Application Ref:	3/2020/1074	 Ribble Valley Borough Council www.ribblevalley.gov.uk	
Date Inspected:	26.1.2020		
Officer:	LE		
DELEGATED ITEM FILE REPORT:		Decision	REFUSE

The application seeks consent for the conversion of the garage to habitable accommodation and construction of a new double garage on the front corner of the site with link extension to the main house.

PROPOSED GROUND FLOOR PLAN

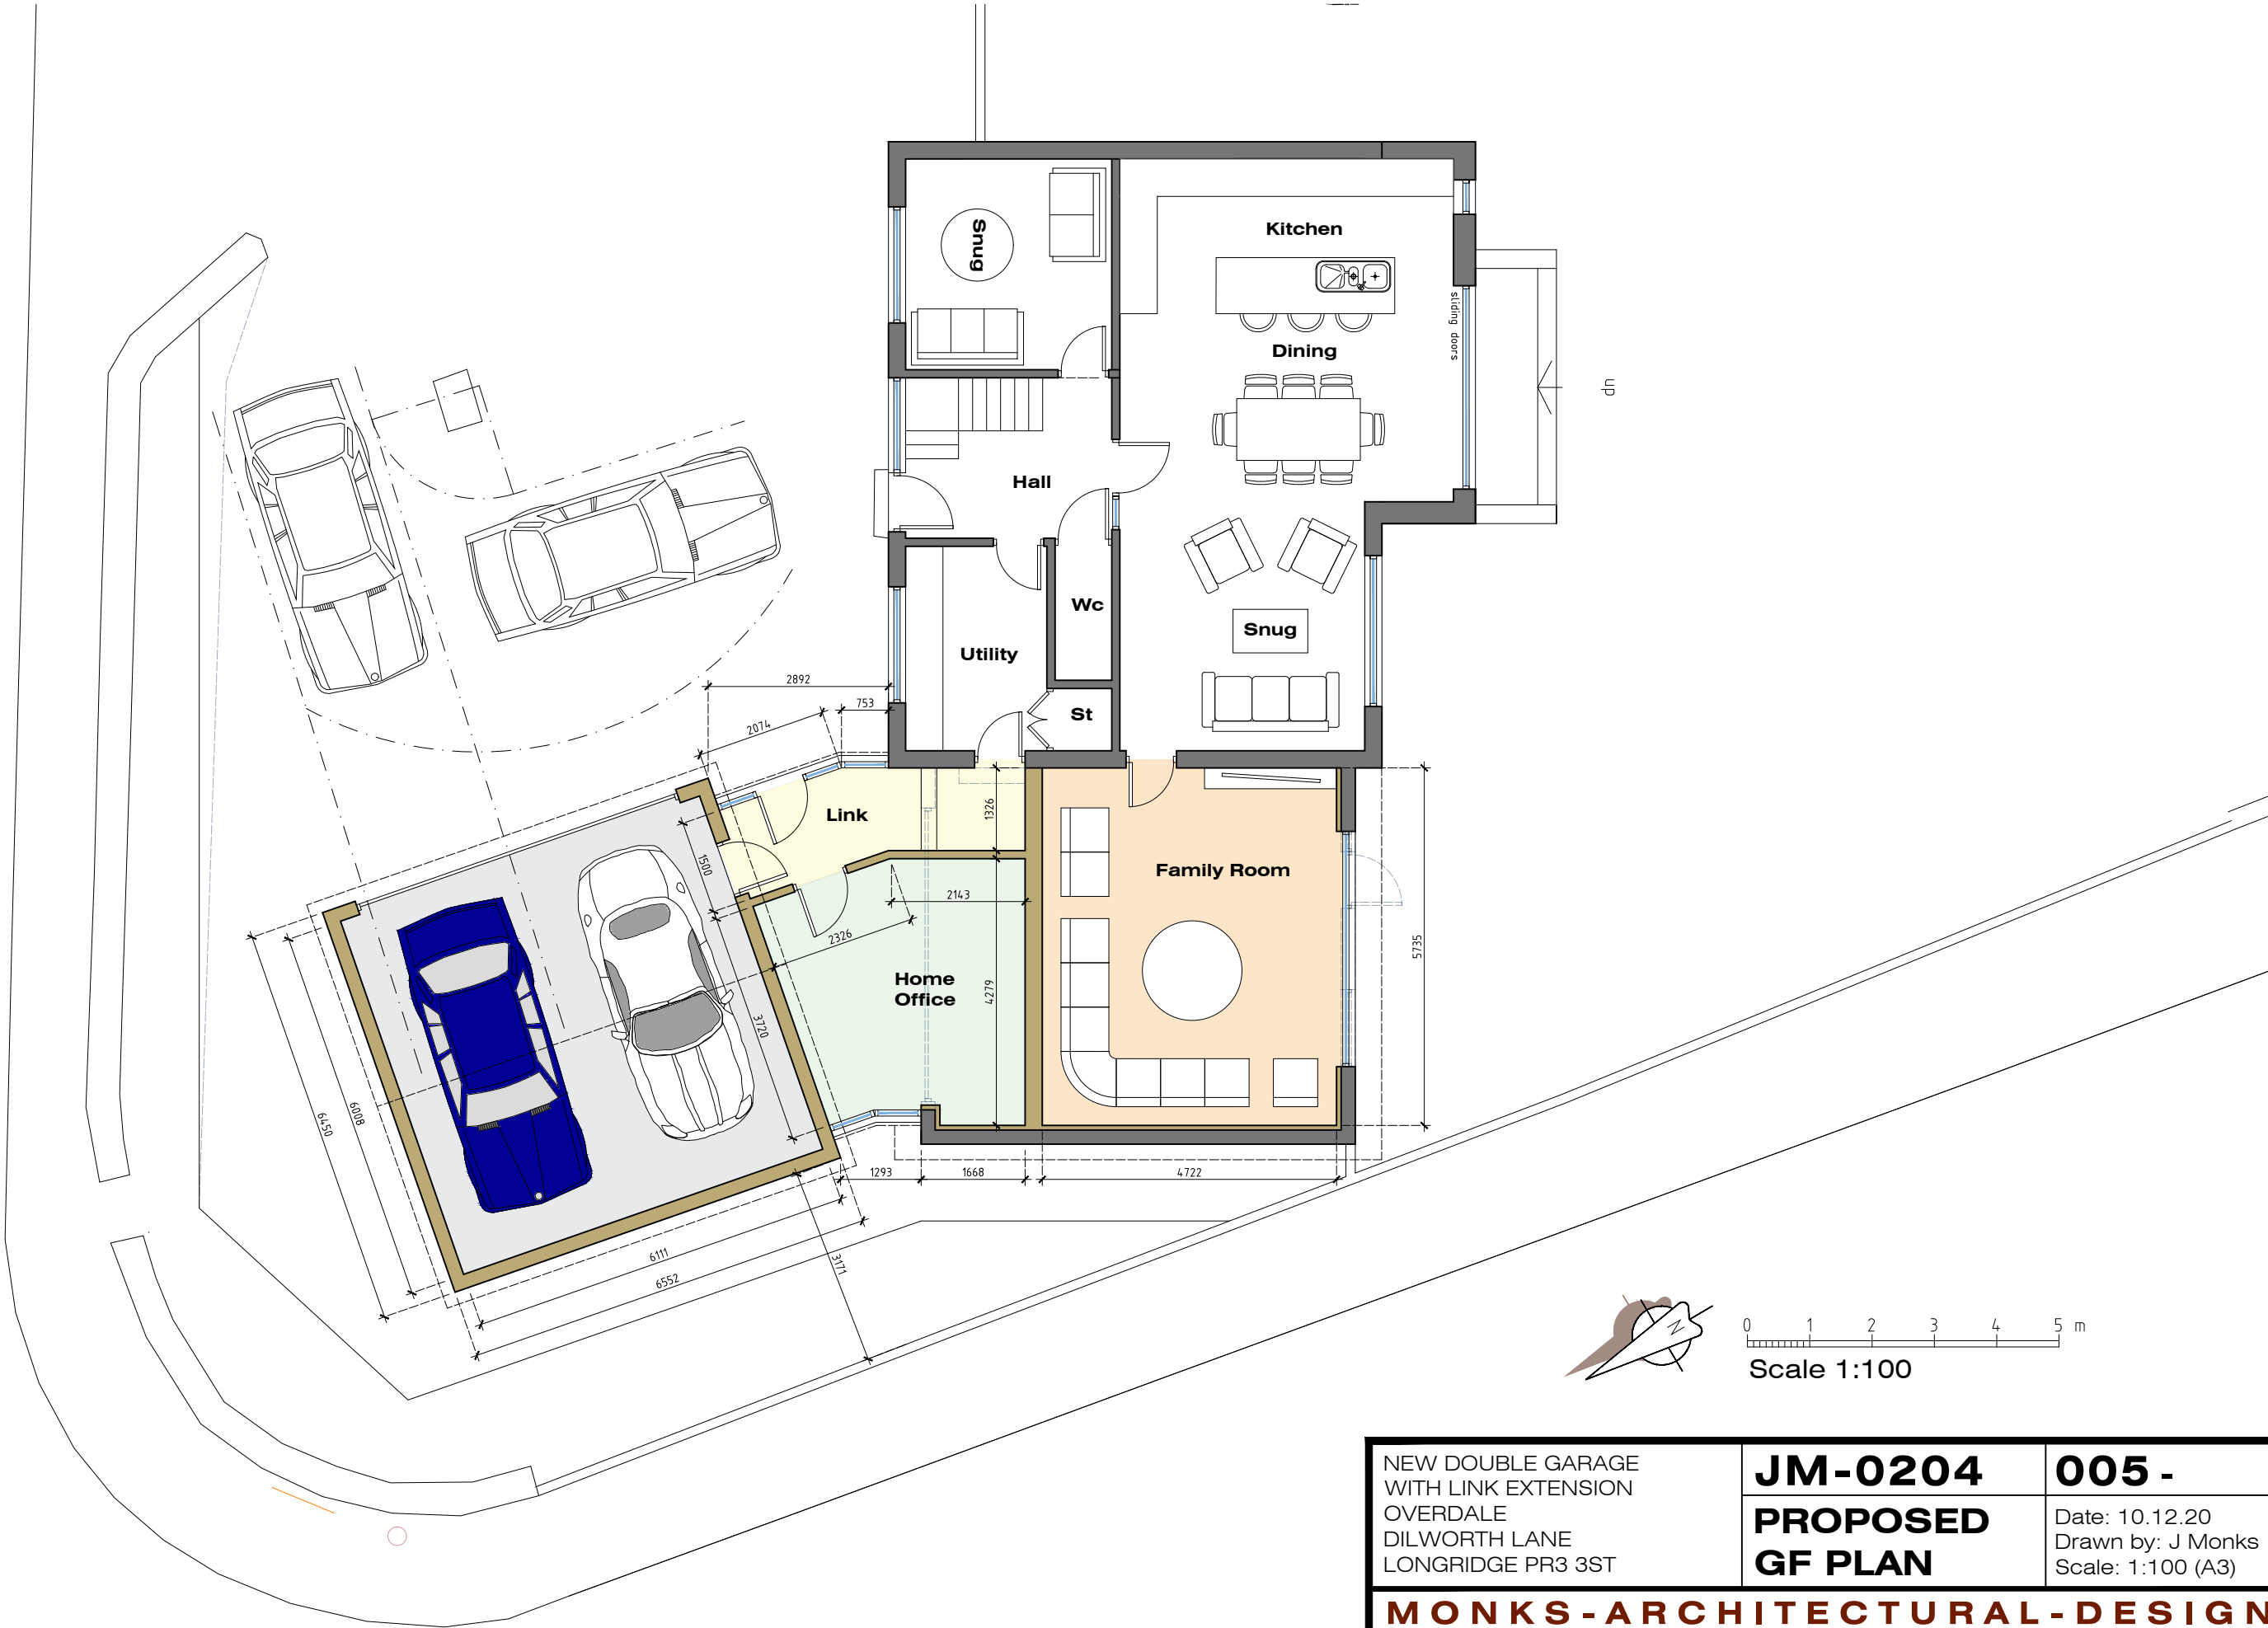
The proposed garage extension is to the front of the property. When travelling along Dilworth Lane in either direction it is characterised by properties which are set well back from the road. Overdale is the closest to the road and the distance gets larger as one travels down the hill. It is considered that the construction of this extension close to the front and side boundaries and the elevated position would disrupt the open spacious character of this street scene and be overdominant. As such it is considered that it would have a harmful impact on the street and visual qualities of the surrounding area and the choice of white render would exacerbate this impact. The proposal is therefore contrary to policy DMG1.

The property has a generous driveway to the front and it is demonstrated on the plans that at least 3 cars can be accommodated off street with room for turning which is adequate for a 4 bedroom property.

The proposal due to its scale and position close to the front boundary of the property on a prominent and elevated corner would be a strident and over dominant feature in the street scene at odds with the prevailing pattern of development. It would be harmful to the visual qualities of the area contrary to policies DMG1 of the Core Strategy and therefore it is recommended accordingly.
